18 December 2014

BIKESydney's submission to the CBD and South East Light Rail Modification Report – State Significant Infrastructure Approval (SSI 6042)

Appendix B.6 Alison Road Indicative Staging Plan

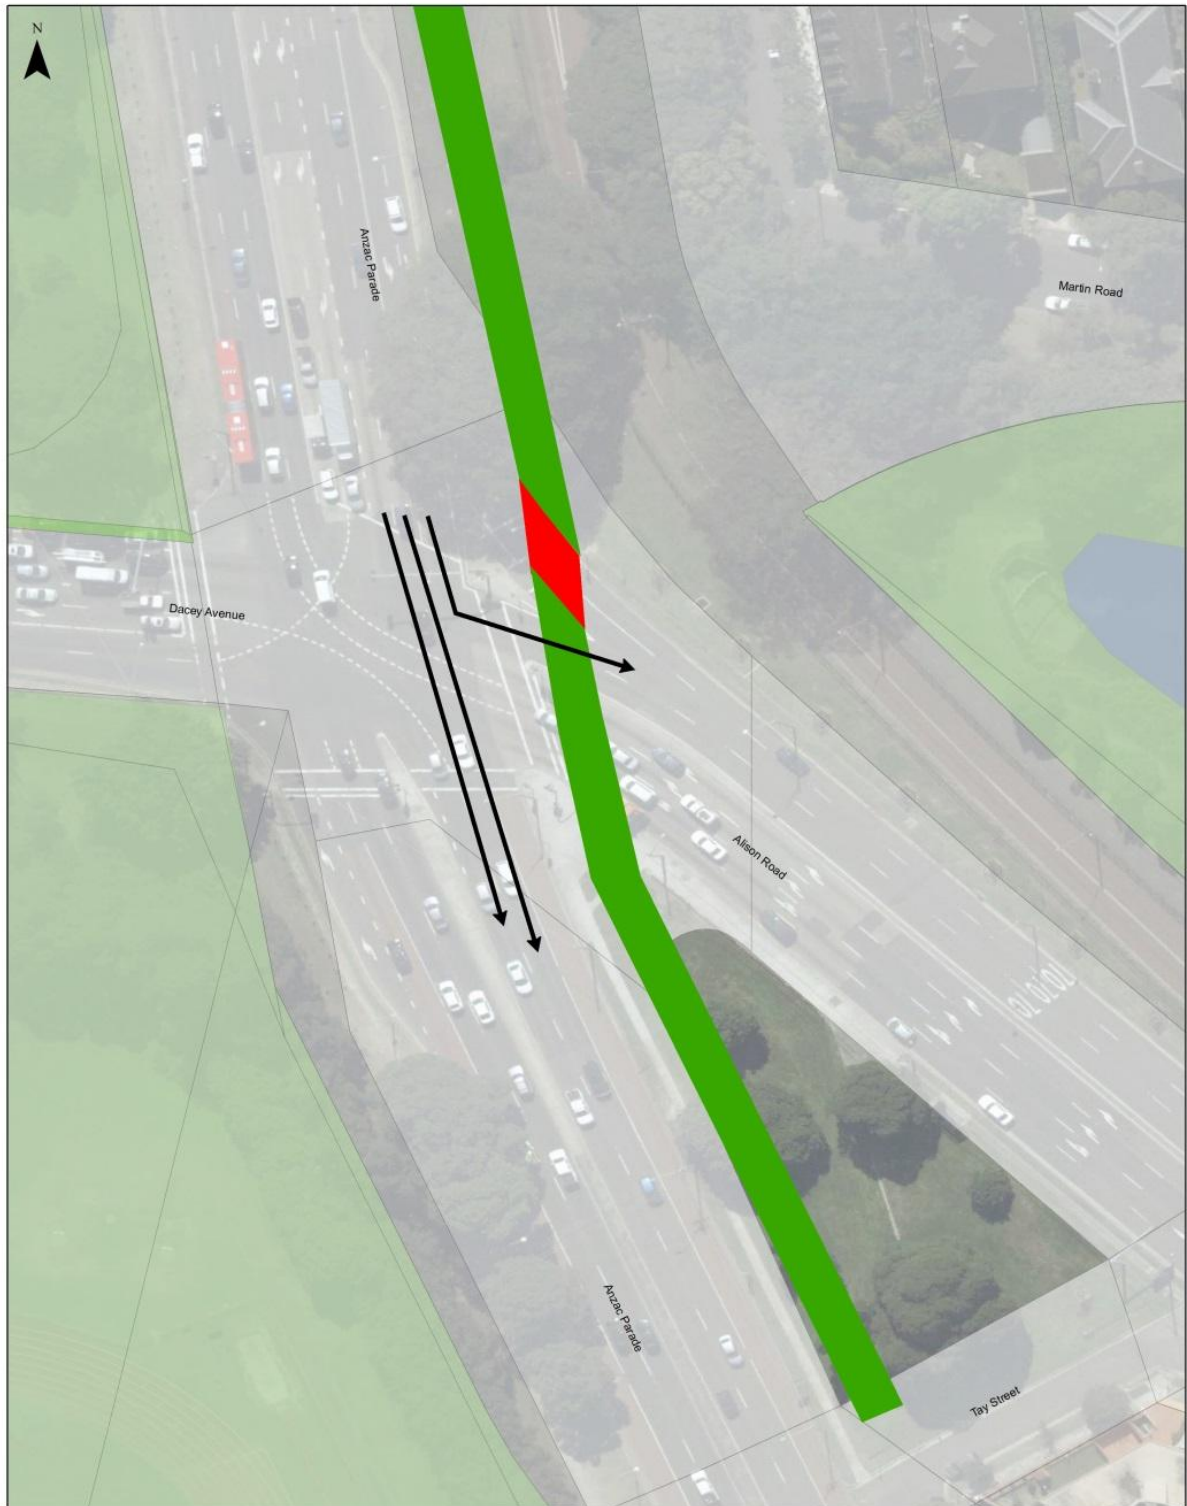
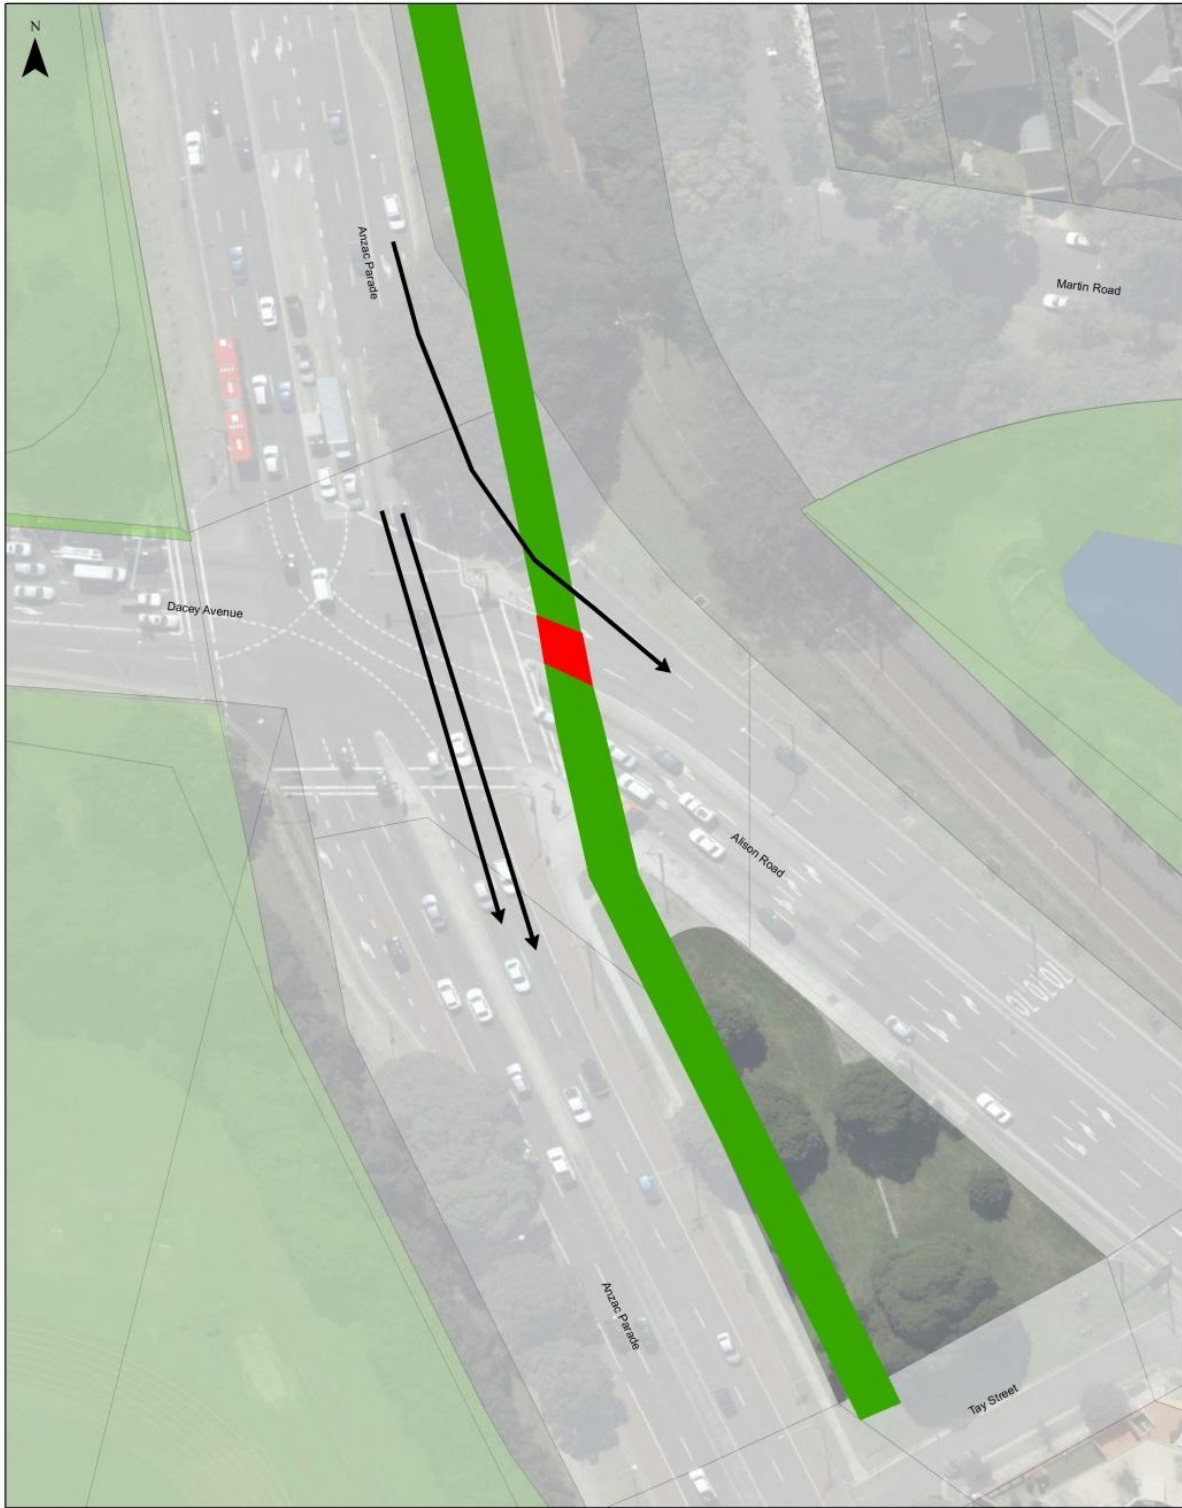
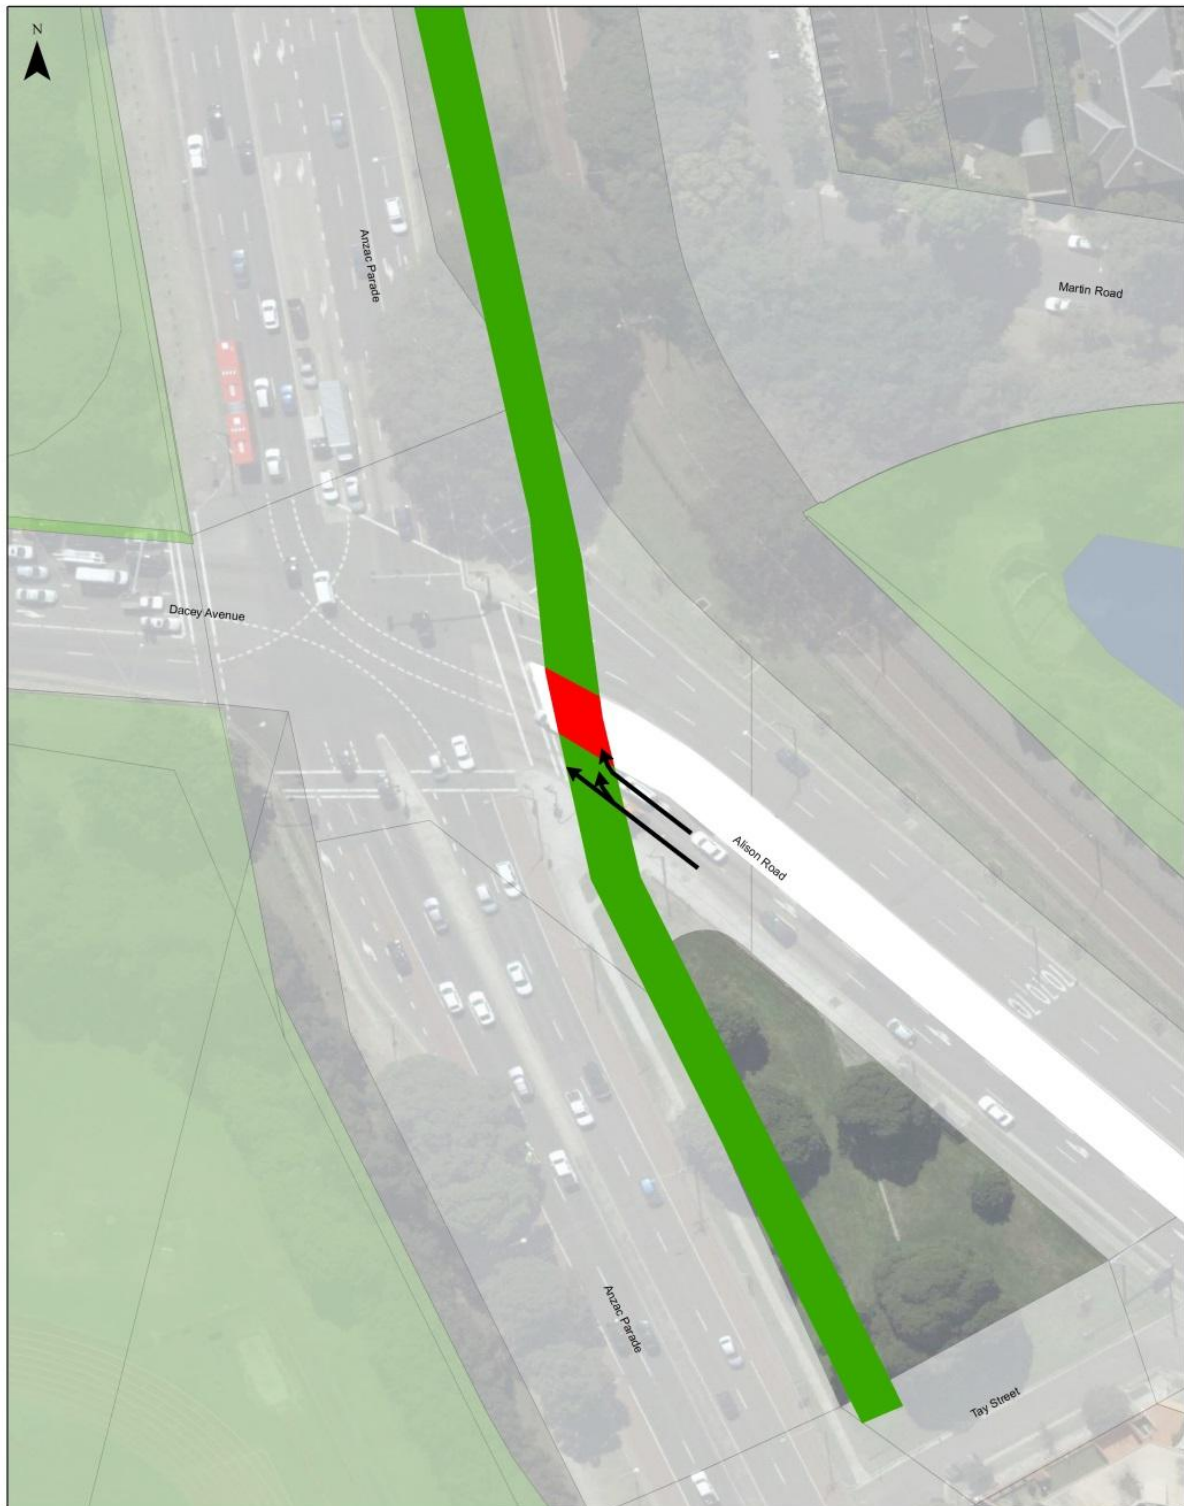
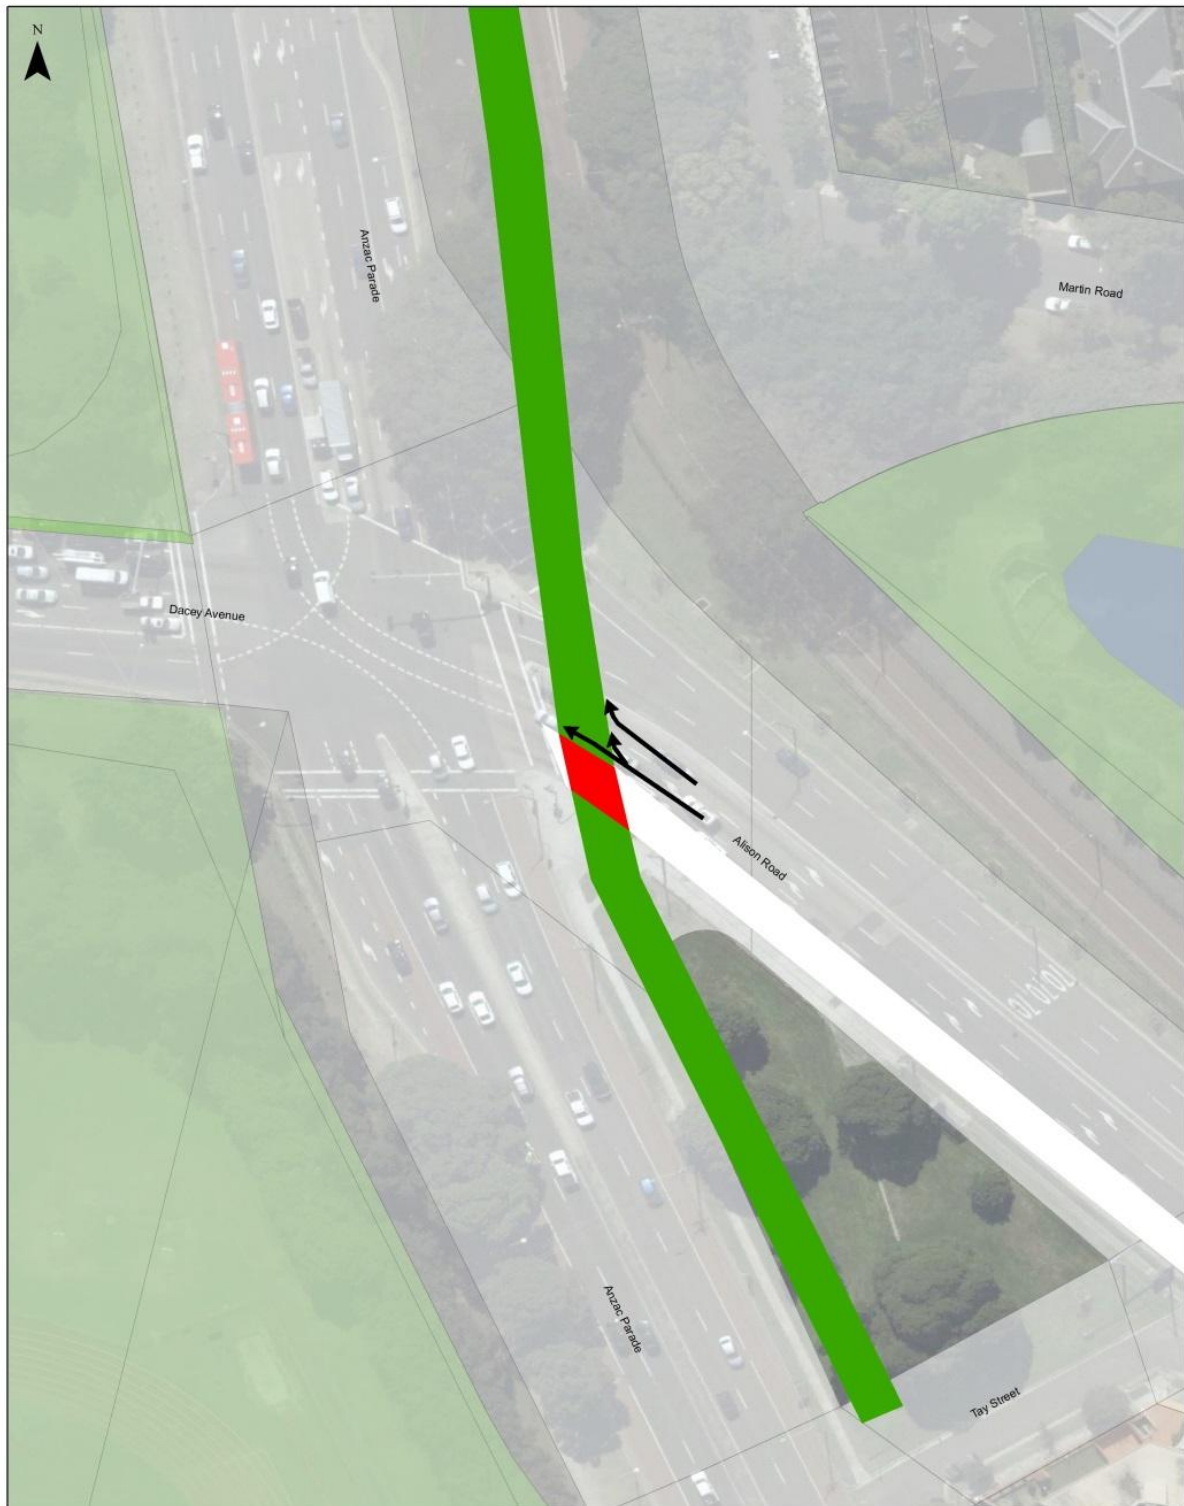
- The Modification Report ignores impacts on, and opportunities for cycling;
- The relocation of the Racecourse stop to the northern side of Alison Rd will remove a newly-provided cycleway (note: not shared path), decrease the catchment potential of the light rail, appreciably decrease safety for (often alcohol-affected) racecourse patrons leaving Randwick Racecourse race day events and also come at the cost of parklands and trees. Tellingly, the State Government has used these same justifications to avoid providing a safe riding connection from the deck of the “Tibby” Cotter Bridge (Anzac Parade) to the Anzac Parade shared path. Consequently, riders will now have to cross the high-speed busway to make that connection, despite the fundamental purpose of the bridge being to remove this risk;

- Relocate the main cycling corridor to the southern side of Alison Road, for the full length between Doncaster Avenue and Wansey Road, to ensure good connectivity with the existing cycling network. This is the preferred alignment from a policing and personal security perspective. The proposed shared path on the levee bank should remain as an alternate route to avoid conflicts during special events. The facility on the southern side of Alison Road must be designed as a SEPARATED path (not a shared path), with a landscaped buffer between the walking and cycling components;

- Provide cycling crossings on BOTH the eastern and western sides of the newly-proposed light rail crossing of Alison Rd (east of Doncaster Avenue). The safe crossing of a major impermeability such as Alison Rd is critical for cycling. It would not be acceptable for the project to ignore the responsibility to provide these cycling crossings. This is in keeping with all Transport for NSW transport planning principles.
